8 March 2021

Your ref: SSD MP09 0161 Mod 2

### **Wongawilli Colliery North West Mains Development (SSD: PA09\_0161-Mod-2)**

H. Middleton  
Manager Mining Impacts  
Dams Safety NSW

Figure 3 Proposed works

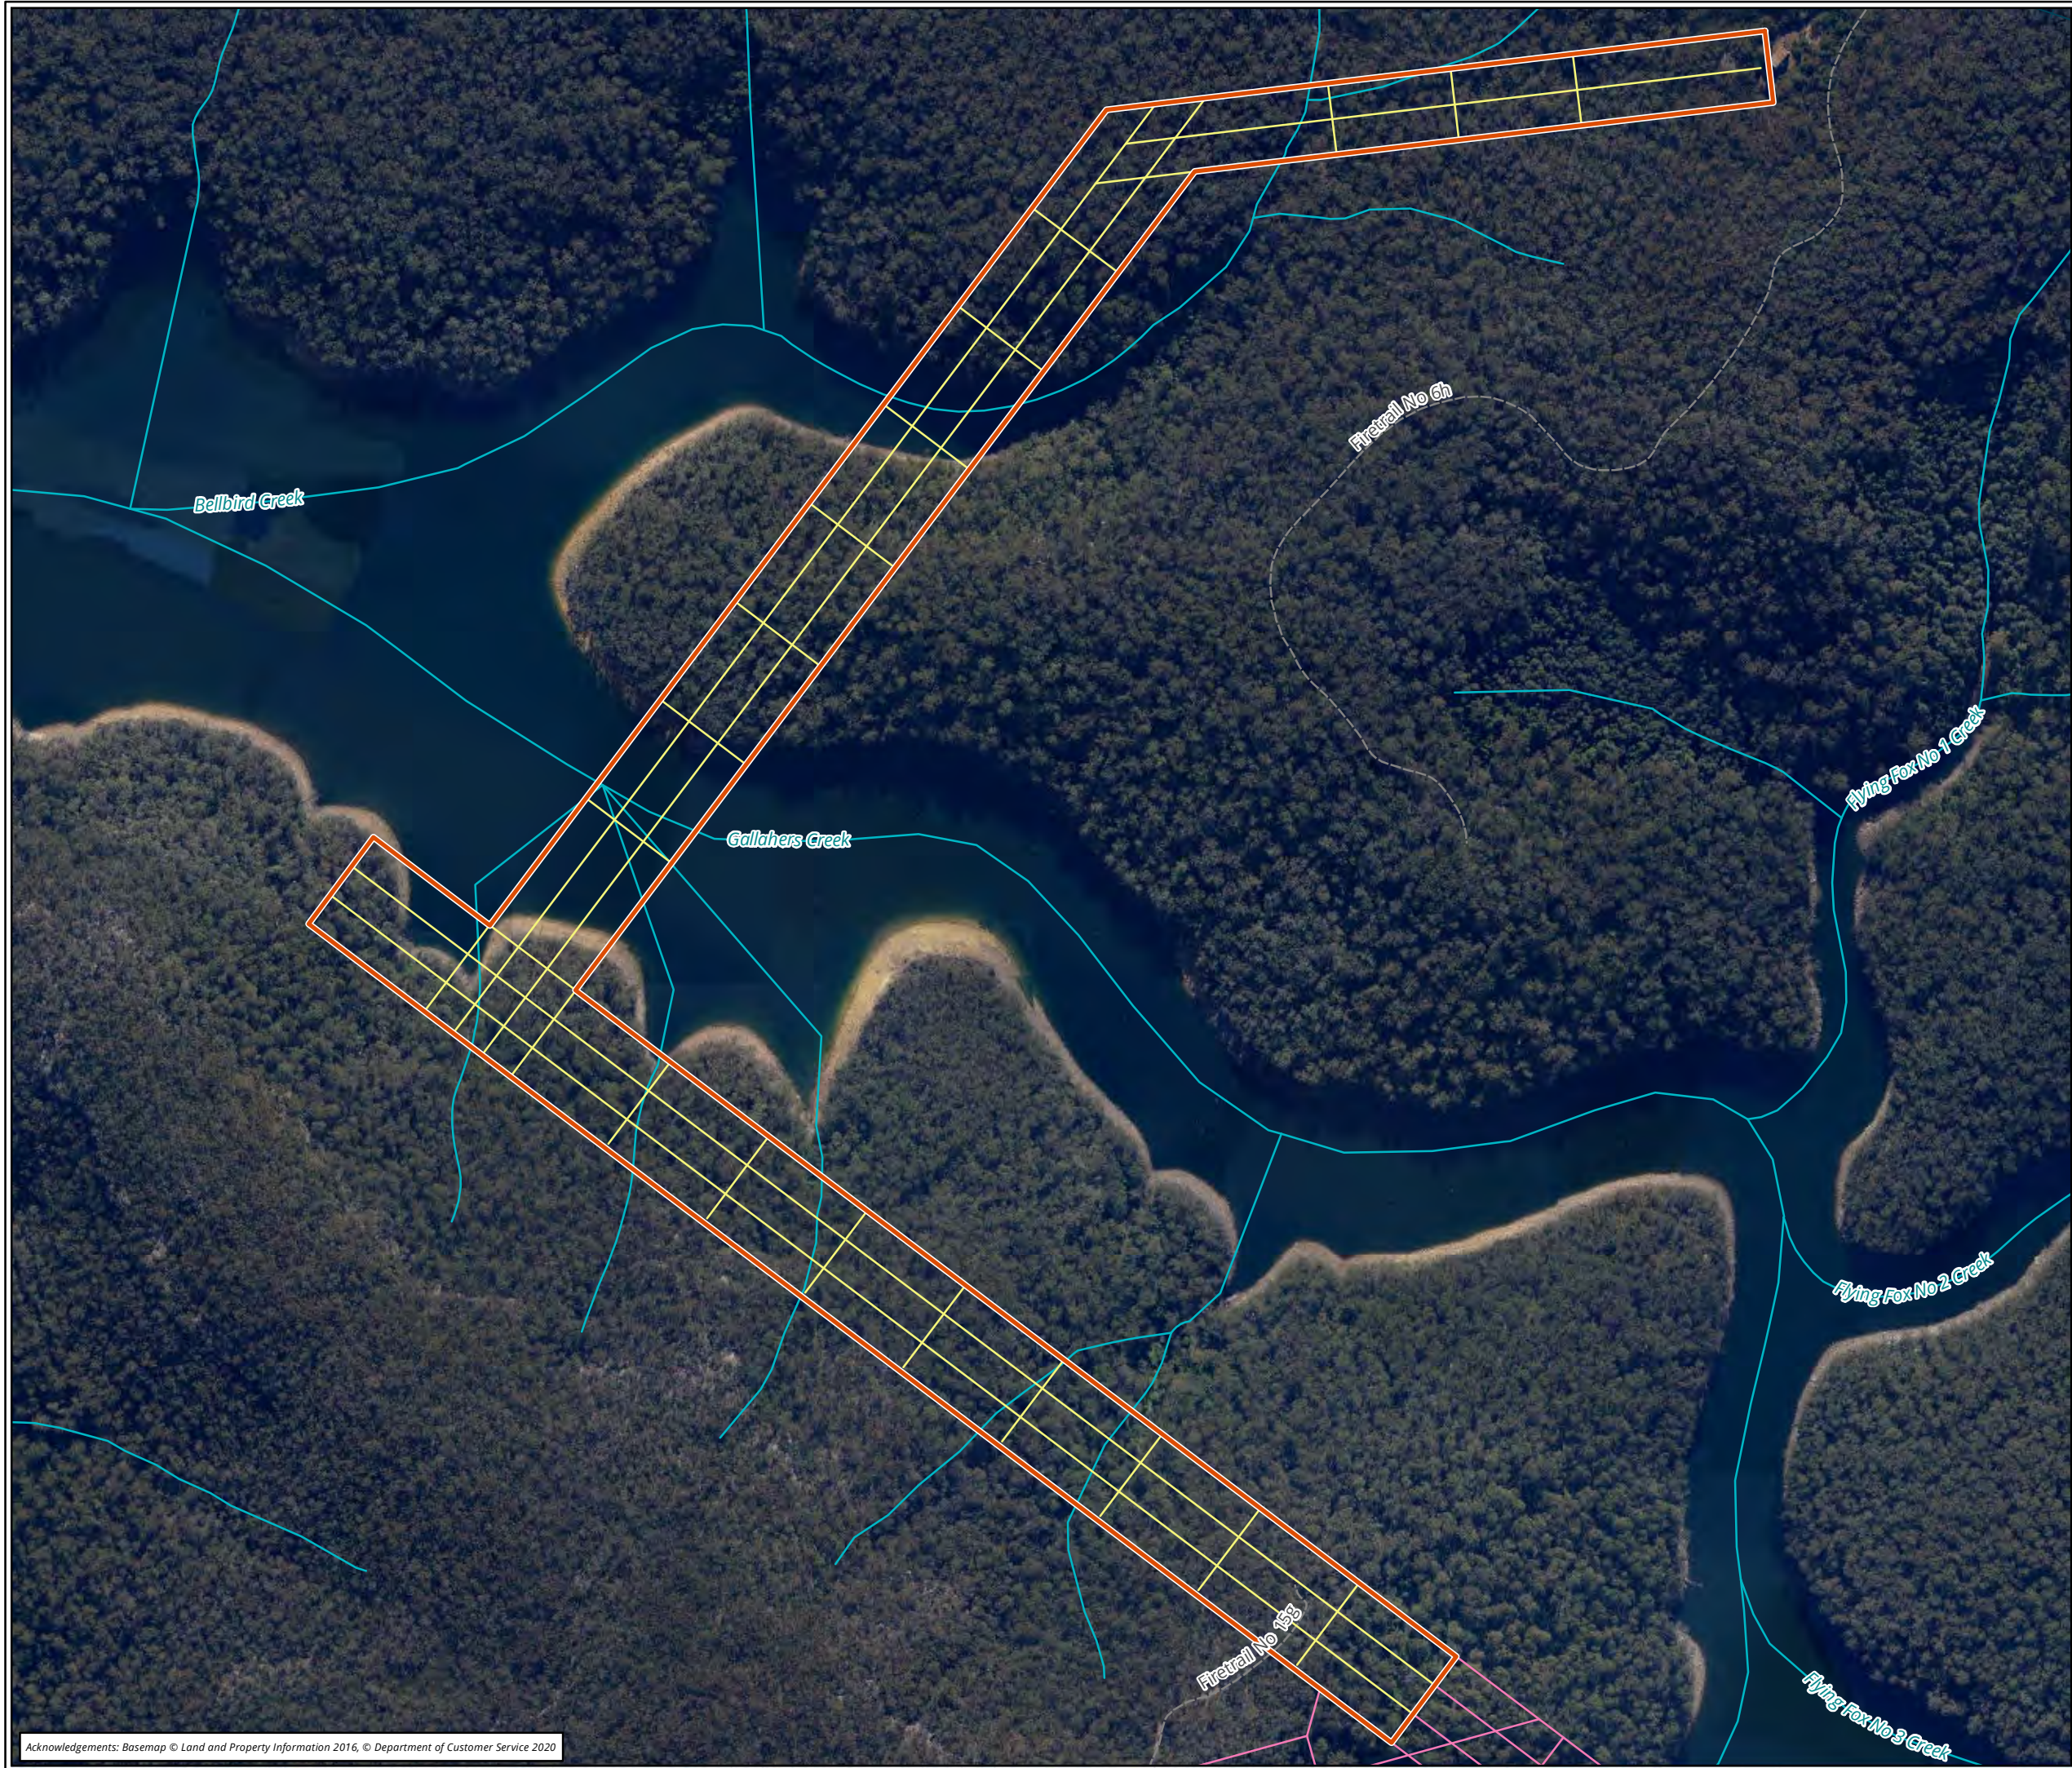
As it is however, the proposed mining in the current development involves driving main roads under one of the Avon Reservoir arms with depths of cover as low as only 60m. Mining at such shallow depths under reservoirs is unprecedented in the Southern Coal Fields.

The full extent of any structural complexity in the local geology will only be revealed as the workings proceed, however several faults intersecting the strata beneath the reservoir arms have already been identified as has at least one dyke.

Faults and dykes intersected during mining in the Southern Coal Fields have so far been found not to transmit water, with the dykes themselves often being demonstrably impermeable. One of the reasons the faults do not act as conduits for water is because the pressure of the overburden keeps the faults in compression. This might not be the case in the proposed mining due to the shallow depth of cover.

Additionally while local dykes are themselves impermeable they coke the coal into which they intrude and can result in porous permeable regions of cinder. The following is therefore recommended:

- That the mine will develop and implement appropriate subsidence monitoring programs.
- That the mine will undertake in-seam drilling well ahead of main development to establish an understanding of any structures ahead of the mining which might result in connections developing between the mine and surface.

- That the mine undertake water monitoring measuring both volume and hydrochemistry of the waters entering the mine, establishing a base line water fingerprint and water make well prior to mining under the reservoir. This will provide early indications that joints or faults are opening up or that the provenance of the waters are changing for example from groundwater to reservoir water.

- That the mine develop a series of emergency TARPs that include the notification of any relevant organisations (eg WaterNSW, DSNSW) should water make significantly increase.

- That the mine develop a Contingency Plan to prevent or halt inrush, prior to developing roadways beneath the reservoir
